**Your Ref:** OWPC5313  
**Our Ref:** FG/45/15/PL 05-03-2015  
**Please ask for:**  
Mrs A Gardner

Change of use of land from agricultural/compost production to B8 Storage. This application is a Departure from the Development Plan  
Hangleton Nursery Hangleton Lane Ferring

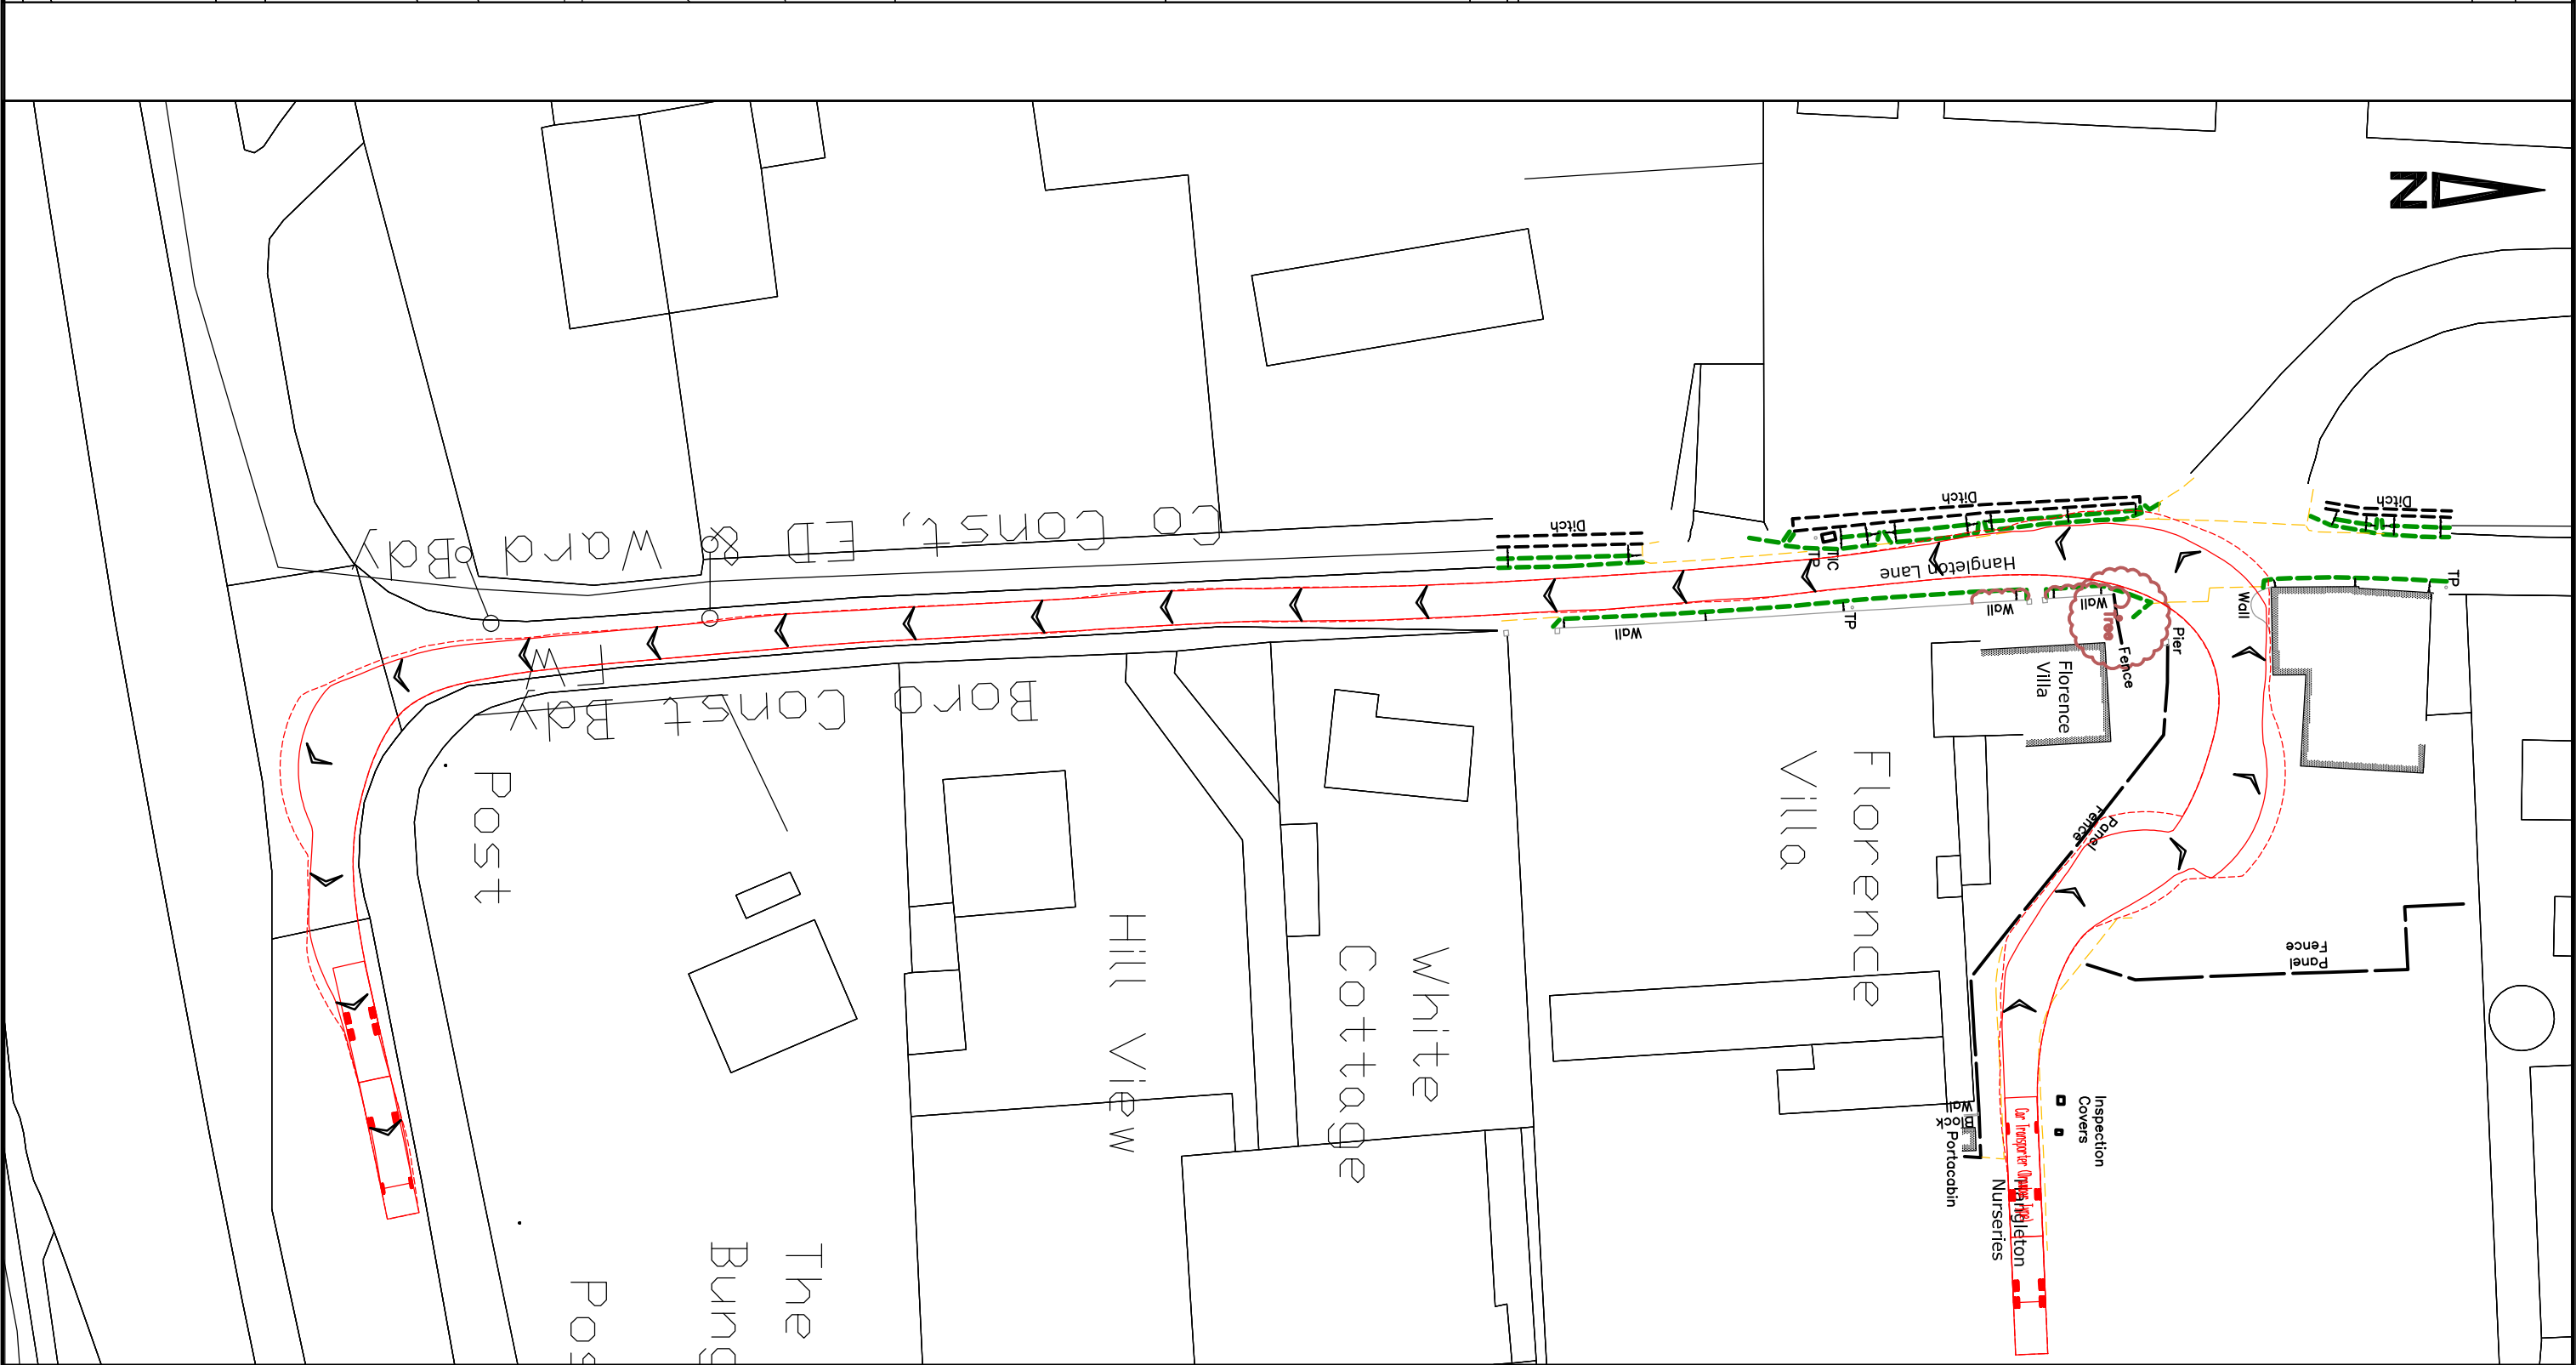
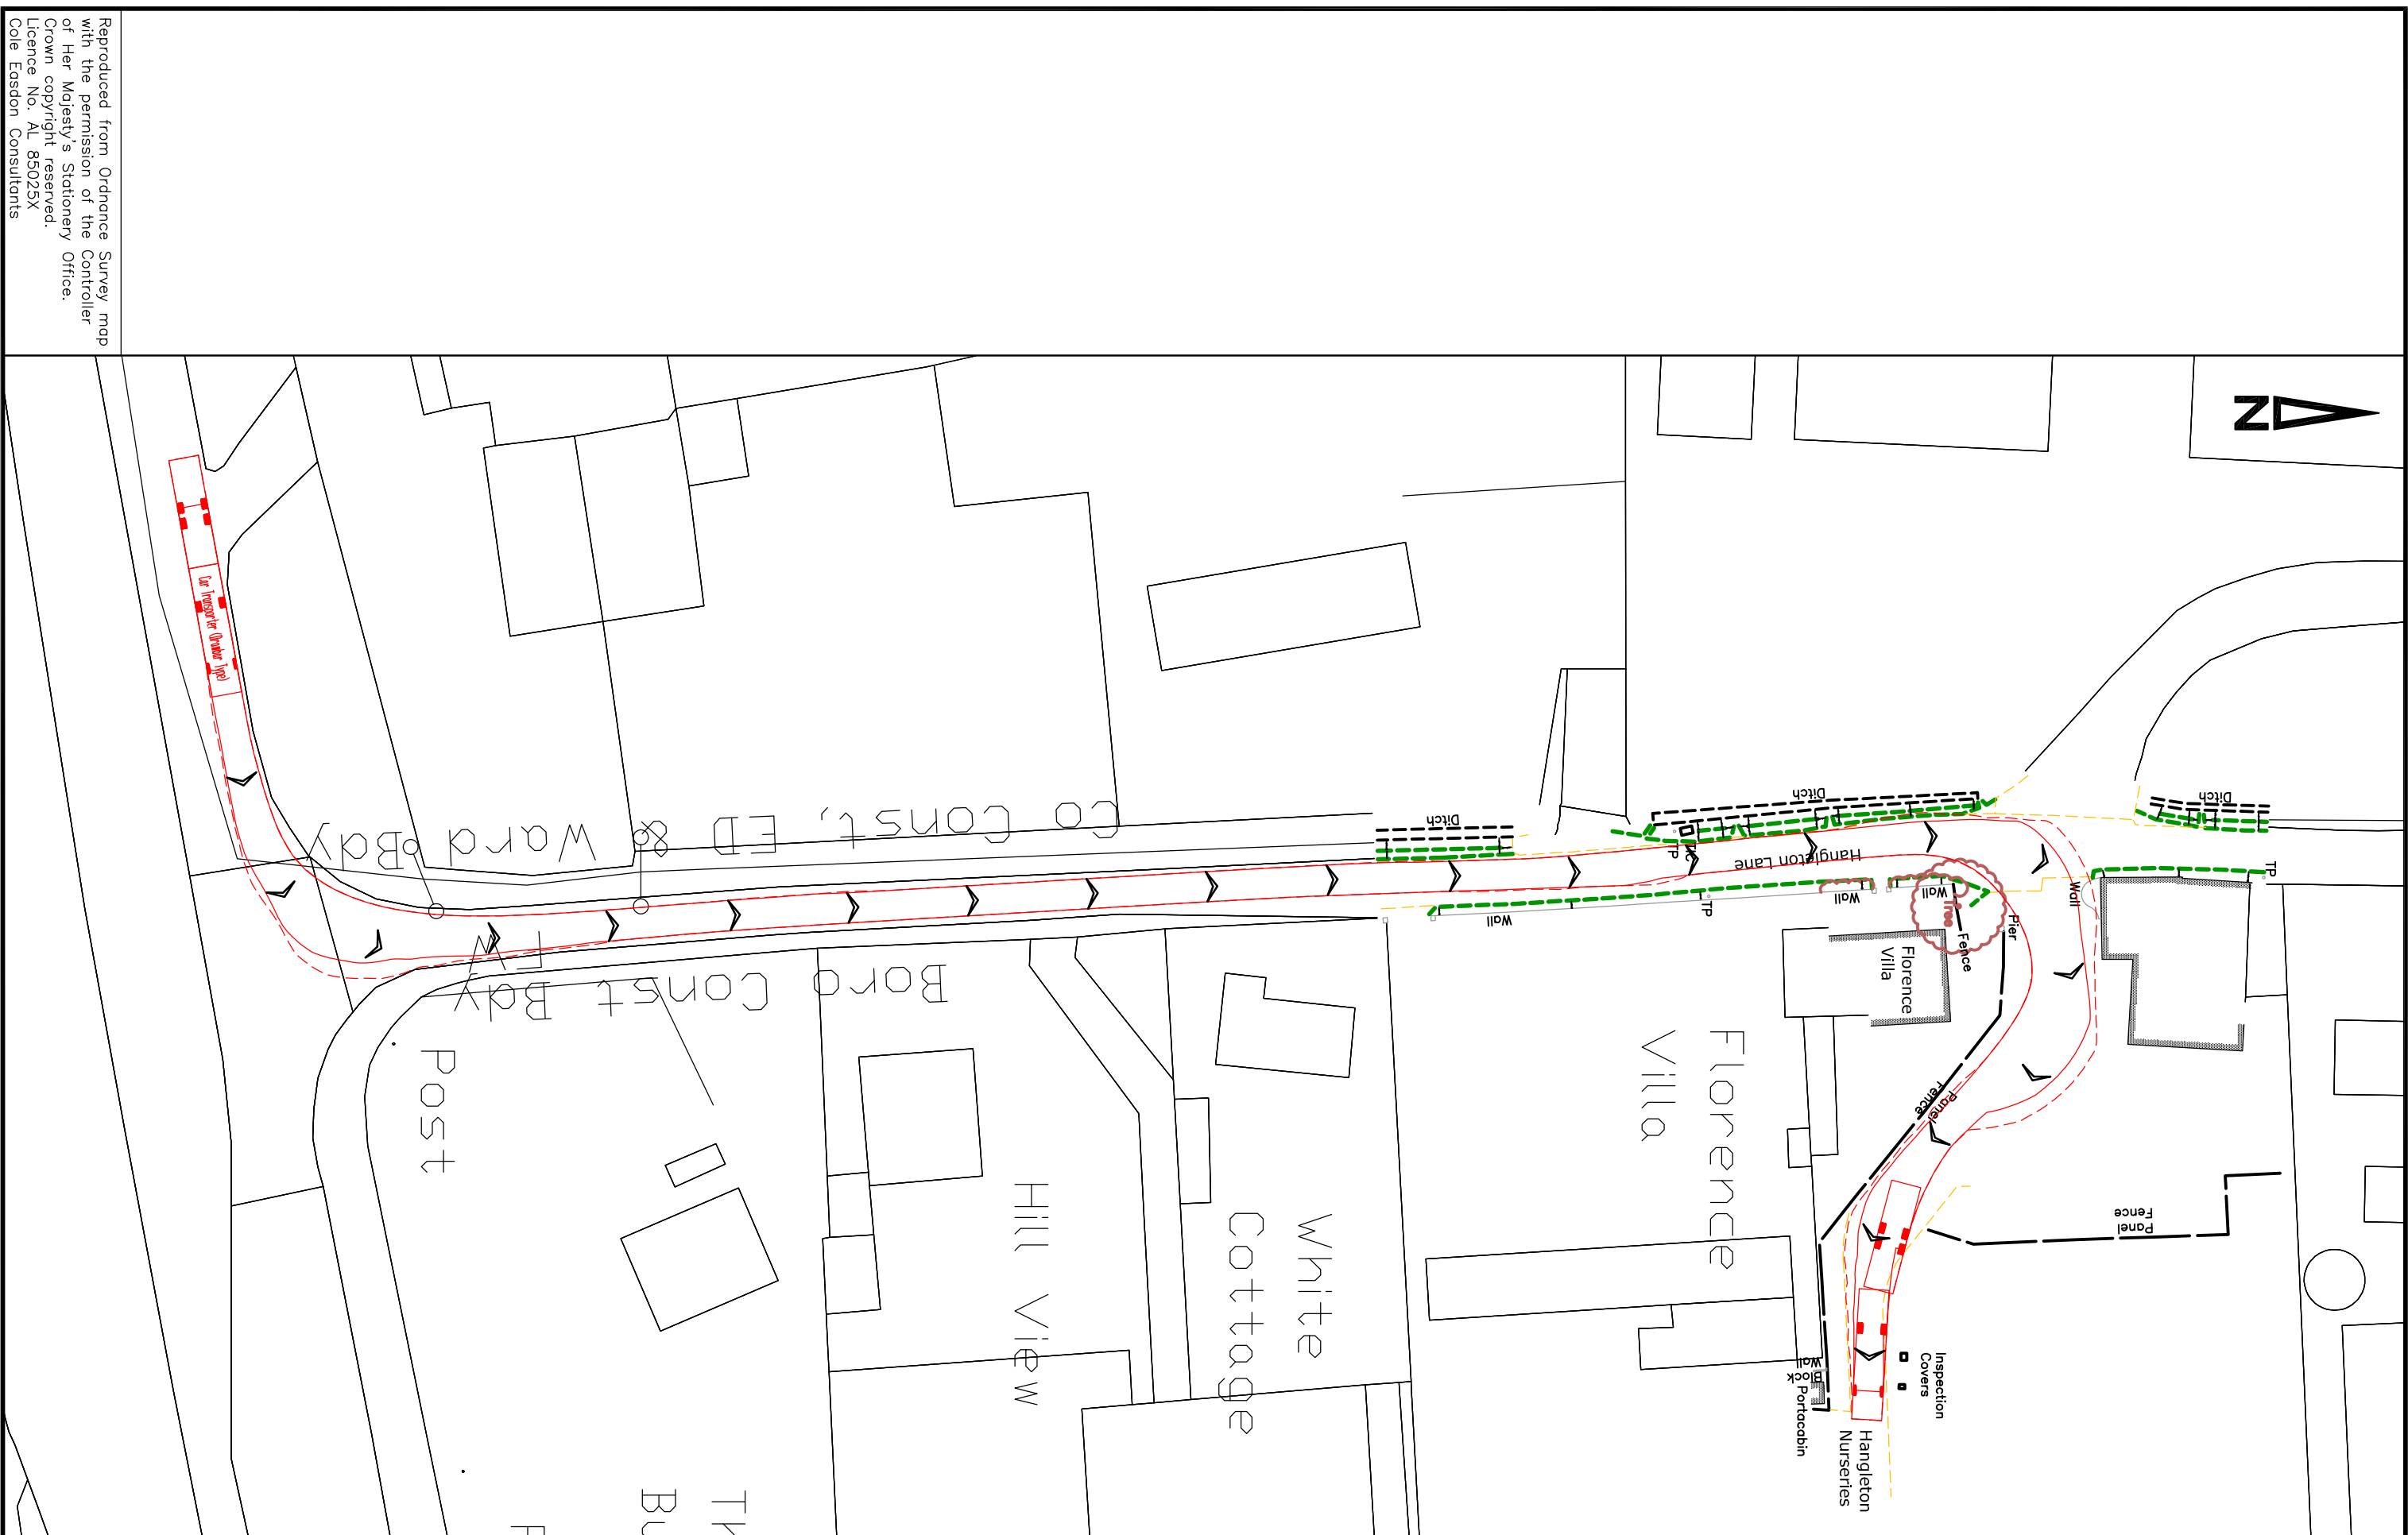
*(1) The so-called 'swept path analysis' for the transporter is incorrect in that its inevitable encroachment onto the outside lane of the A259 when turning into Hangleton Lane is not shown. This is potentially very dangerous on this road where traffic is often moving at 70 mph.*

*(2) There are 75 horses at Hangleton Farm Equestrian Centre and 8 at WADARS which can exit there to cross the A259 for Ferring beach and the Ilex Way. There is enough random traffic to cope with on a horse or pony leaving the lane without the intrusion of a transporter 19 meters long. (I use this junction at least ten times a week either on a bike or horse).*
